Date: 08-Jun-2023
Our Ref: 2023/91600

**Application for Approval of Details Reserved by Condition
Town and Country Planning Act 1990
Planning (Listed Buildings and Conservation Areas) Act 1990**

**Discharge of conditions 6 (sheltered cycle parking), 16 (electric vehicle charging) of
previous permission 2014/90411 for erection of 2 blocks of student accommodation
At land adjacent, Manchester Road, Huddersfield
Application Number: 2023/91600**

DRAWING
Block B Ground Floor
Proposed

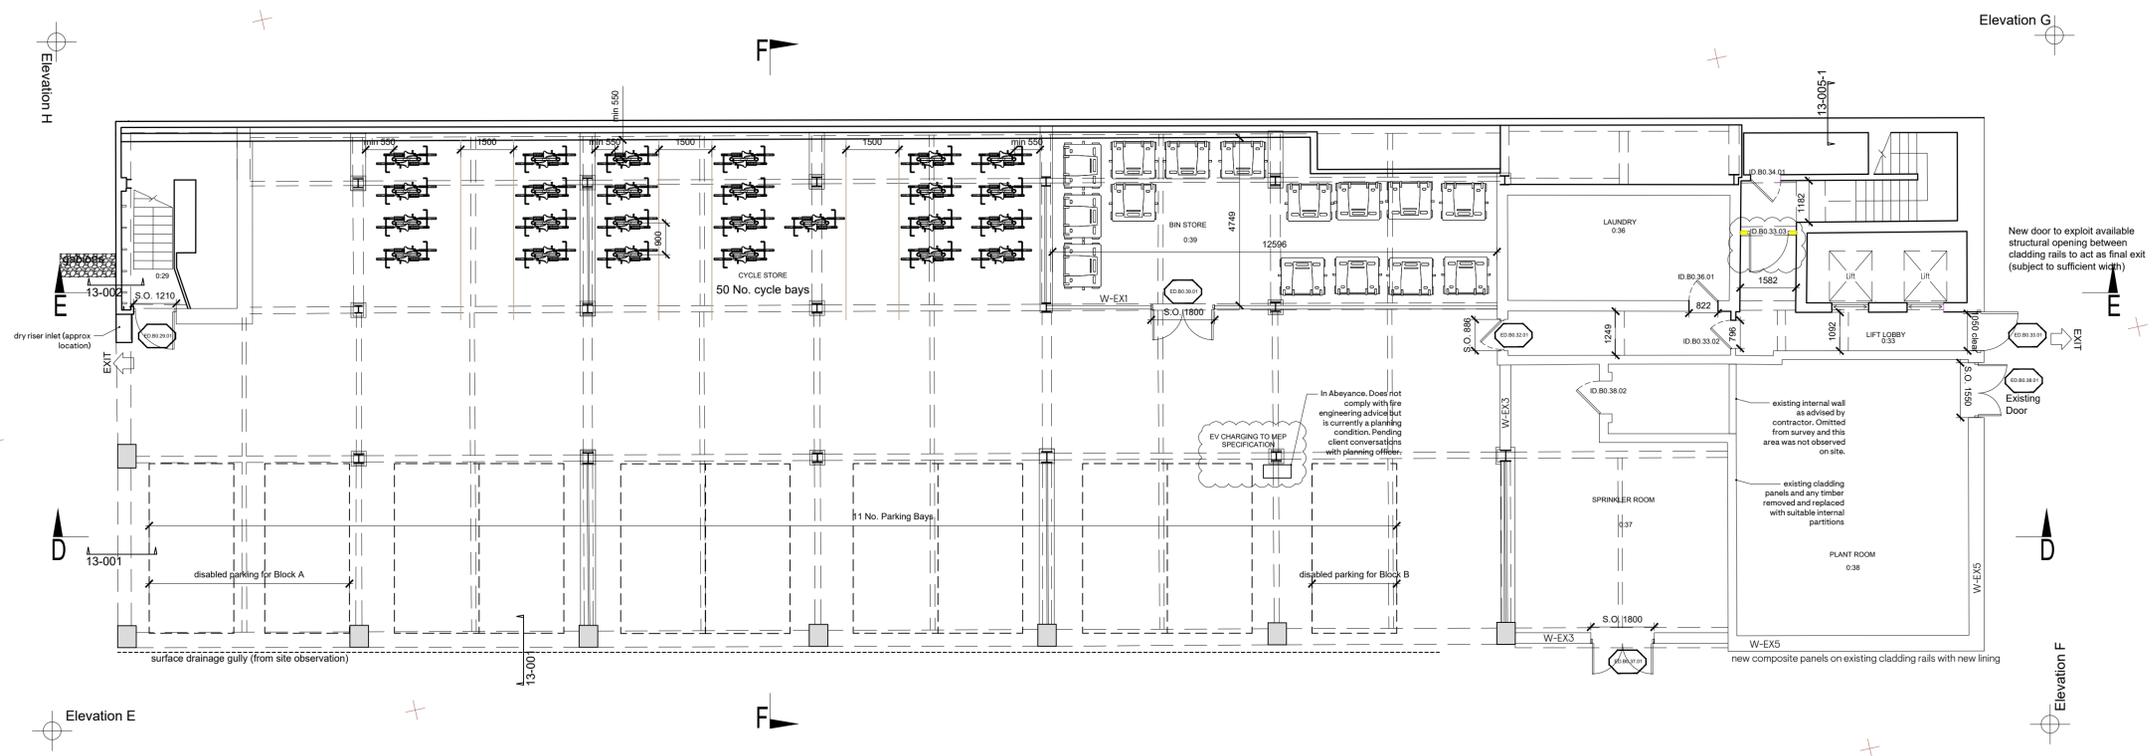
- A plan labelled Block B Ground Floor Proposed (drawing HUD-KKA-BB-00-DR-A-03-011)

The information submitted is acceptable for the purpose of condition 6. It is noted however,
that the facilities should be retained free of obstruction and available for use, throughout
the lifetime of the development.
